Ribble Valley Borough Council
Council Offices
Church Walk,
Clitheroe
Lancashire
BB7 2RA

Phone: 0300 123 6780
Email: developeras@lancashire.gov.uk
Your ref: 3/2026/0369
Our ref: 3/2026/0369/HDC/KW
Date: 23 July 2026

Location: 15 Clitheroe Road Sabden BB7 9HD
Proposal: Proposed single-storey side and rear extension, alteration to garage roof, associated internal alterations and external works to include excavation and construction of a retaining boundary wall.
Grid Ref: 377883 437600

PROPOSED GROUND FLOOR PLAN
Scale 1:50

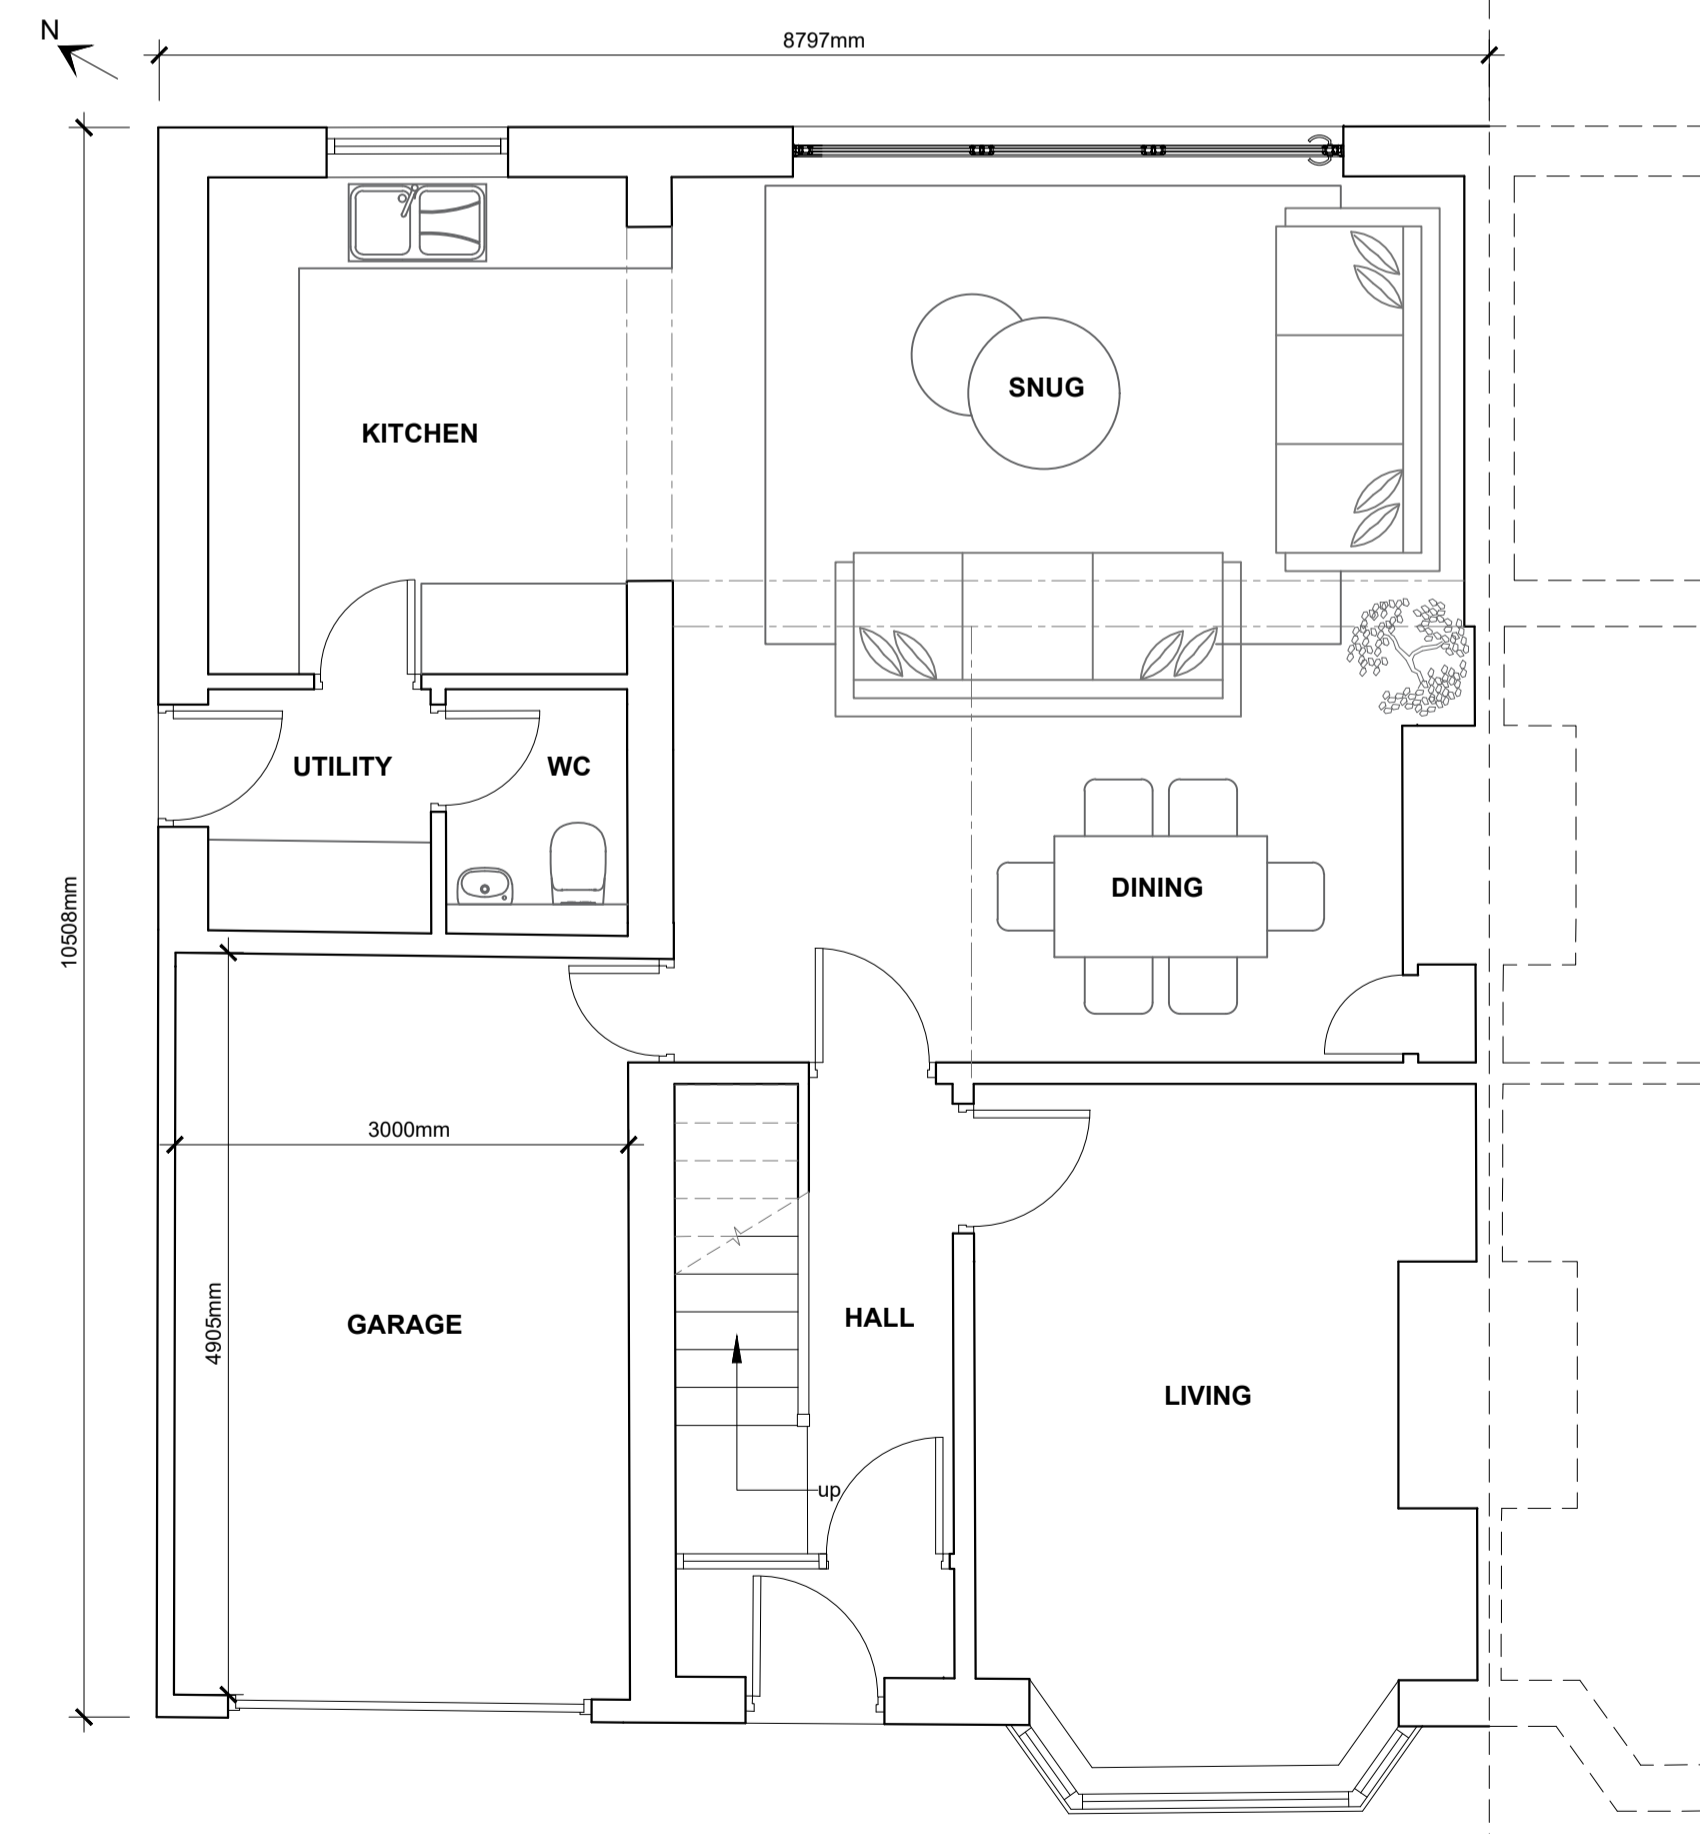
The recommended minimum internal dimensions for a single garage size is 6m in length and 3m wide. The recommended distance of 6m is based on the length of a large family car (Ford Mondeo Estate 4.58m long), clearance at the rear of the car (200mm), overhang of the garage door (600mm) and room to stand in front of the car and open/close the garage door (600mm). Where garages are smaller than the recommended minimum internal dimension of 6 x 3m they should not be counted as a parking space.

PROPOSED SITE PLAN
 Scale 1:100

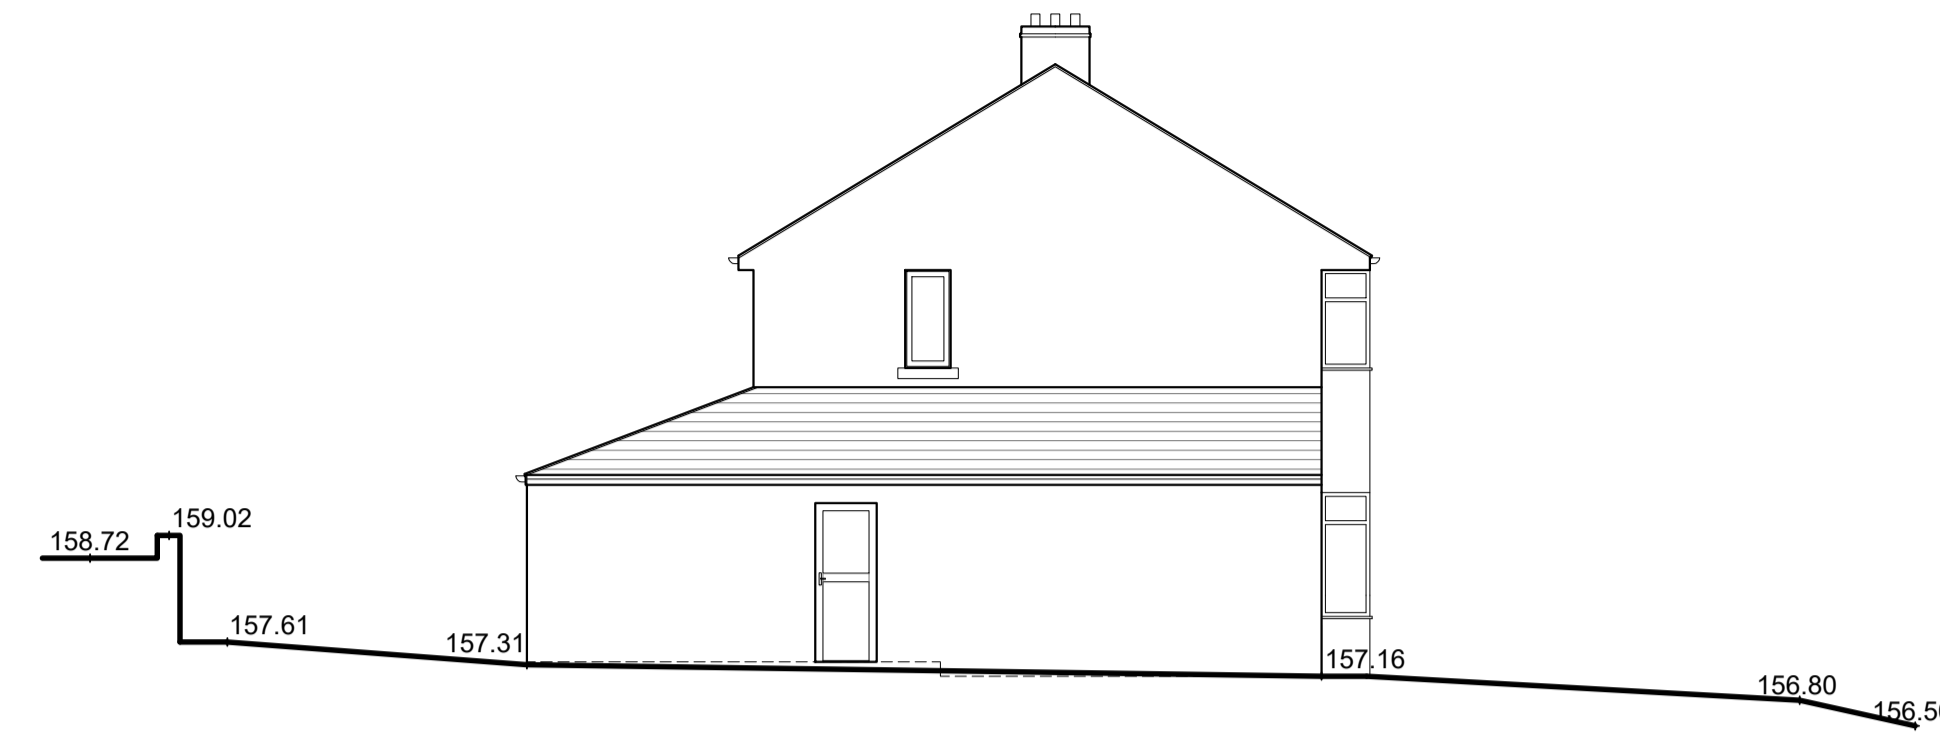
The LHA have reviewed drawing number 2608-03 titled Proposed Site Plan and Sections and are aware amendments will be made both internally and externally. Externally a retaining wall is proposed between the site and the neighbouring property, and it is understood that the wall will be no higher than 1m for the first 7.7m into the site, which will ensure visibility will not be obstructed at either access.

As such the LHA would look for two parking spaces to be provided within the site, one existing space will be retained within the existing driveway fronting the garage; however, to ensure parking provisions remain in line with parking guidance as set out within the Joint Lancashire Structure Plan, the LHA would request that a parking plan be provided.

In order to progress this application, the applicant is required to review the parking provisions within the site and provide a parking plan showing to at least 2 off street parking spaces.
